WEST SUSSEX COUNTY COUNCIL CONSULTATION

TO:	Arun District Council FAO: Obafemi Okusipe
FROM:	WSCC - Highways Authority
DATE:	27 April 2022
LOCATION:	4 Ferringham Lane, Worthing, BN12 5NE
SUBJECT:	FG/58/22/PL Conversion of the top two floors into a 1 No 3 bed flat (resubmission following FG/22/22/PL). This site is in CIL Zone 4 (Zero Rated) as other development.
DATE OF SITE VISIT:	n/a
RECOMMENDATION:	Advice
S106 CONTRIBUTION TOTAL:	n/a

Detailed site plan Not to Scale

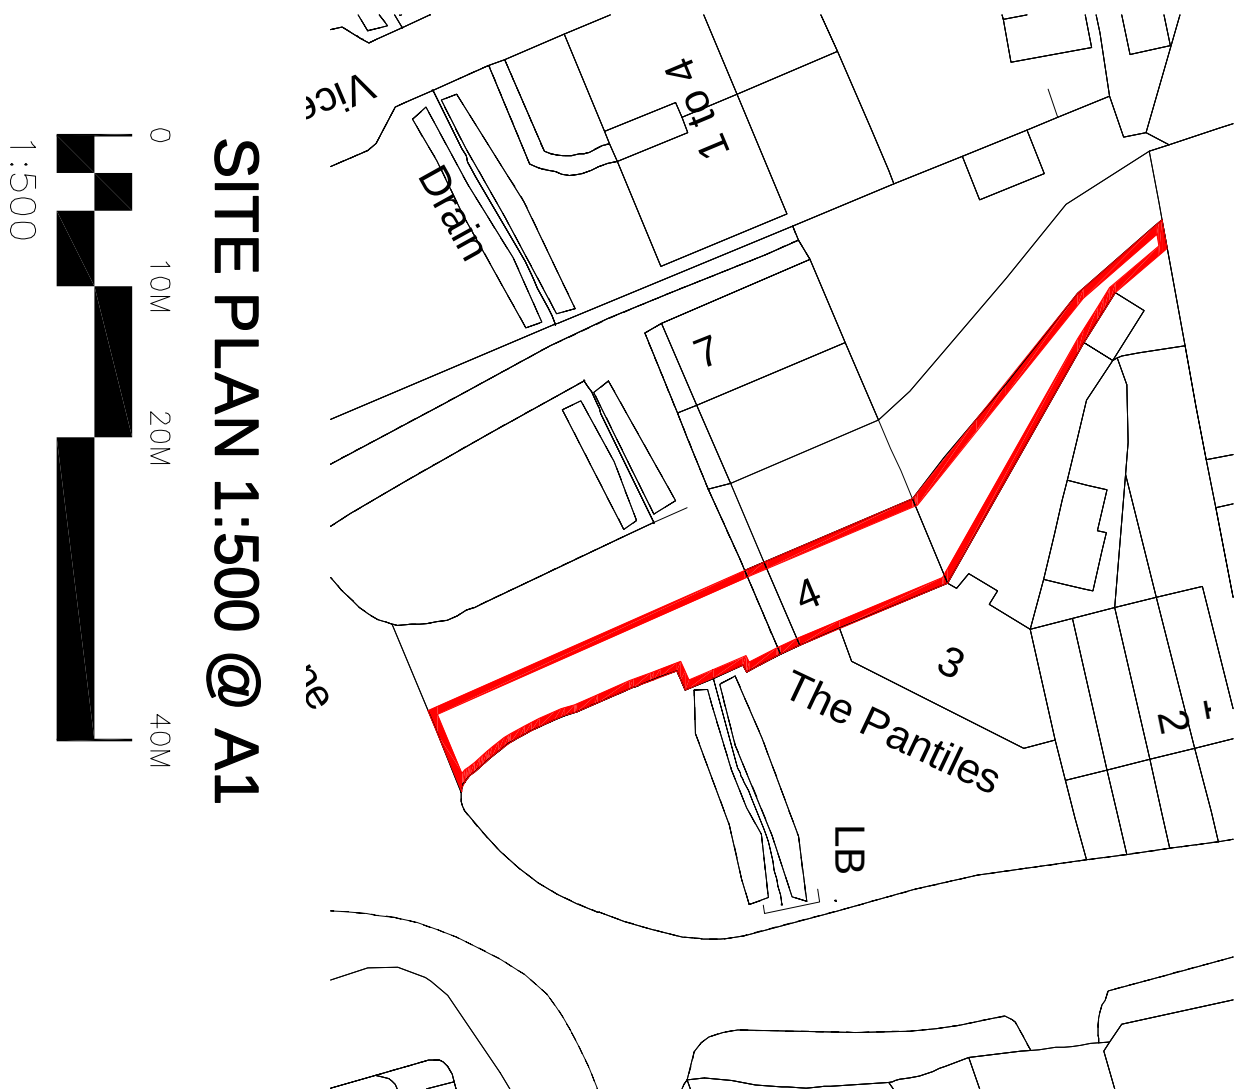
It does not appear that any off-street parking provision is provided for the proposed flat. Using the Arun DC Supplementary Planning Document for Parking Ferring is within parking behaviour zone 2. Therefore, a flat of this size would be anticipated to generate the parking demand for 2 spaces.

When assessing parking consideration needs to be given to the existing use. The existing 4 treatment rooms spread across the two upper floors would have generated its own parking demand which would likely have been similar to the proposed use. The existing parking would likely have made use of what appears to be some communal parking within the site frontage, but outside the red edge of this application. It is not clear if residents of the flats will be able to make use of this provision.

The Local Planning Authority may wish to clarify with the applicant where it is anticipated any parking demand will be accommodated. However, the highway network immediately adjacent to the site is maintained privately. It would therefore not be anticipated that any parking implications, if any, would impact upon the local highway network for which West Sussex County Council is responsible for.

The flats should be provided secure and covered cycle storage. This may not be possible given the constraints of the site. The Local Planning Authority should consider if securing such a provision would be achievable in this case.
